Baxter - Removed stair to third floor

We are proposing to remove one of the 2 stairs that go to the third floor at the Baxter Academy building See attached ASK-6 where we show a small ramp outside the dark room vestibule where the removed stair was. The third floor is going to be unused and we do never plan to use it. Basically it will be vacant space, it is sprinkled and has a fire alarm.

1 SECOND FLOOR PLAN  
 1/8" = 1'-0"

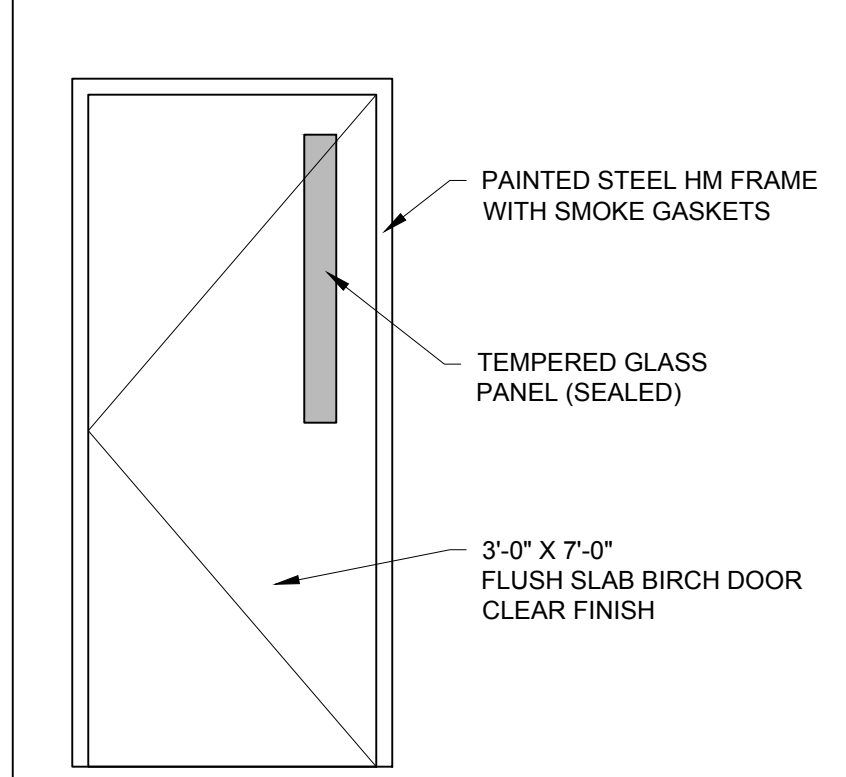
Can you just provide some additional details, ie. the change in elevation, whether handrails are needed & installed, and please bubble the area to indicate the change. Is the ramp across the way on the original plans as new?

Please see Sec. 1003.5 Elevation Change, for changes less than 12", if the ramp is greater than 1:20 and 6" or less, either handrails or contrasting floor finish materials is required.

What are the red rectangular marks? Is this the same change on the other side? If so the same details are required.

Ok, thanks, I have some recollection of seeing a plan with the 3rd floor space, but can't seem to find it. I realize this space is to remain vacant, under the control of the school, and labeled no access, but now an egress from that space is being removed.

Please send a copy of the 3rd floor with square foot area for additional contextual purposes indicating the stair is being removed.

We will make the ramped areas a contrasting floor color. We will make sure all ramps without handrails have a contrasting floor color.

The red marks are where we are removing the old stair to the third floor which is abandoned and will have on access stair.

Here is the 3rd floor plan, I don't show the interior partitions as I have not measured that floor in detail but this shows the stair to be removed.
